EXHIBIT B

PROJECT No. 18029
MAY 23, 2018

RE-ZONE EXHIBIT

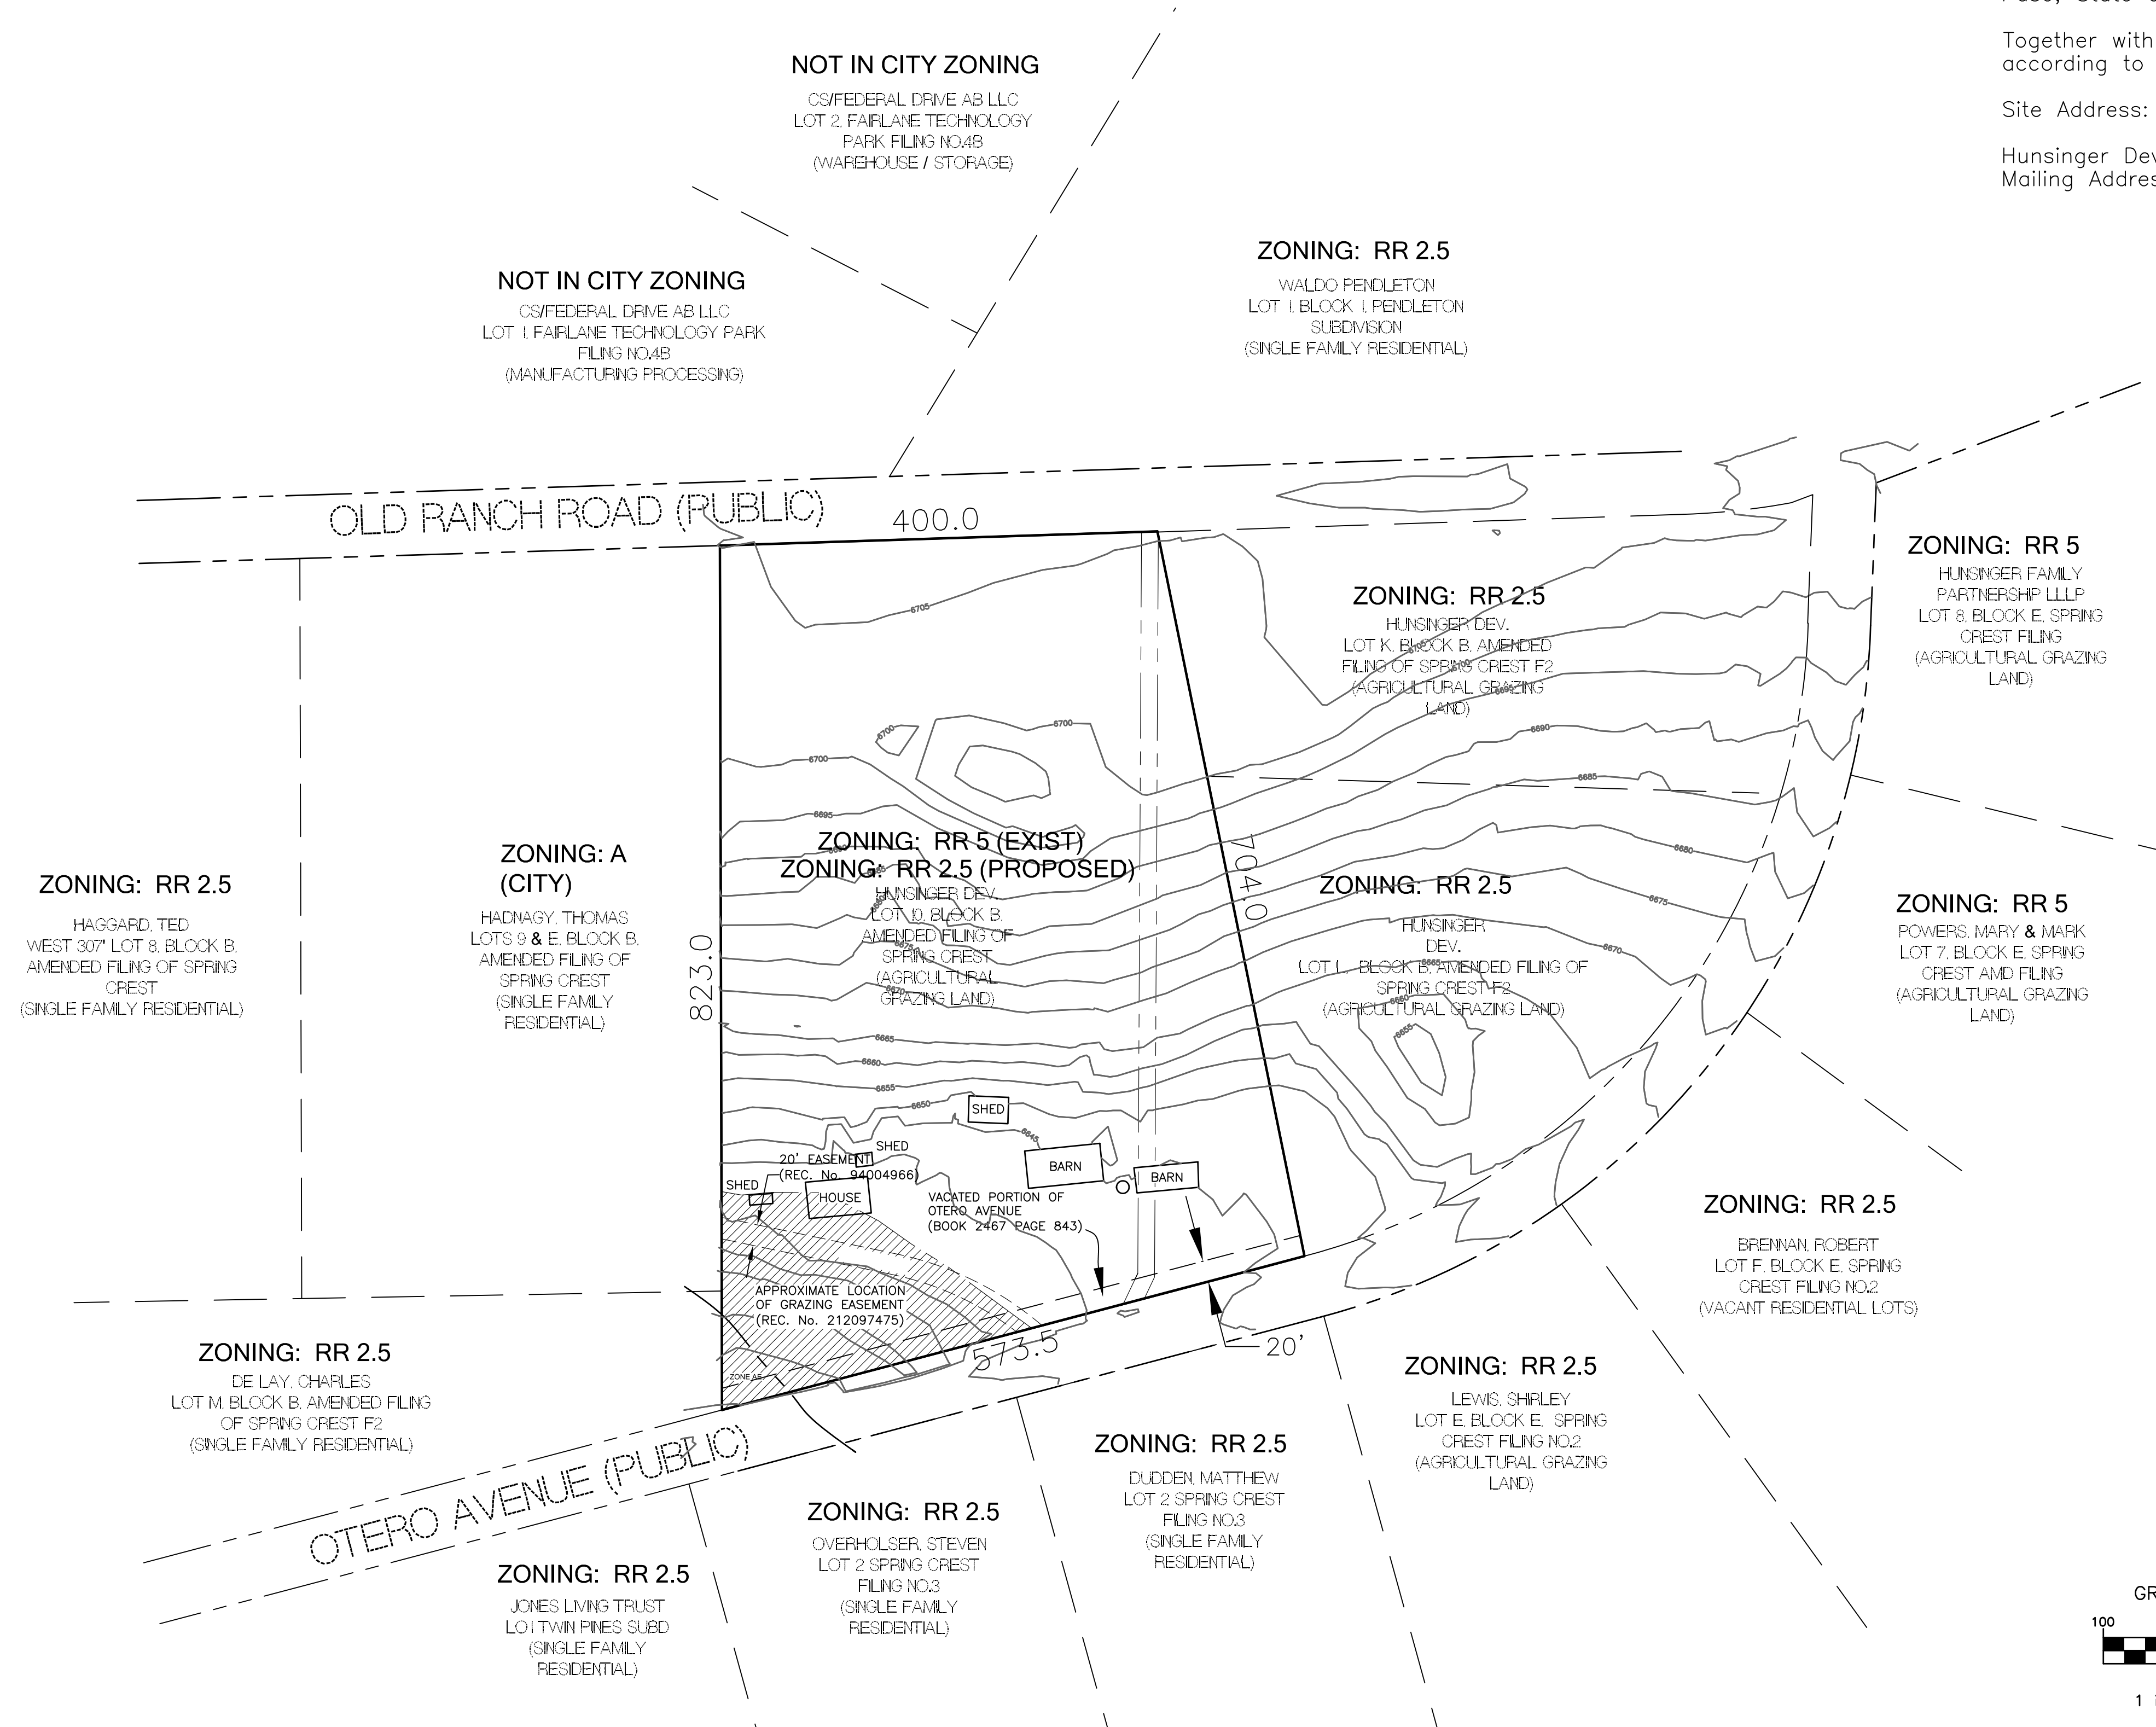
Missing items from checklist:
Existing land uses and zoning on the property and within 500 feet of the boundary.
Adjoining property ownership.
Existing roads, public or private.
Existing structures.
Existing easement.
Name and addresses of the petitioner, owners of all interest, in the property, and preparer.
Existing Topography at 5 feet intervals
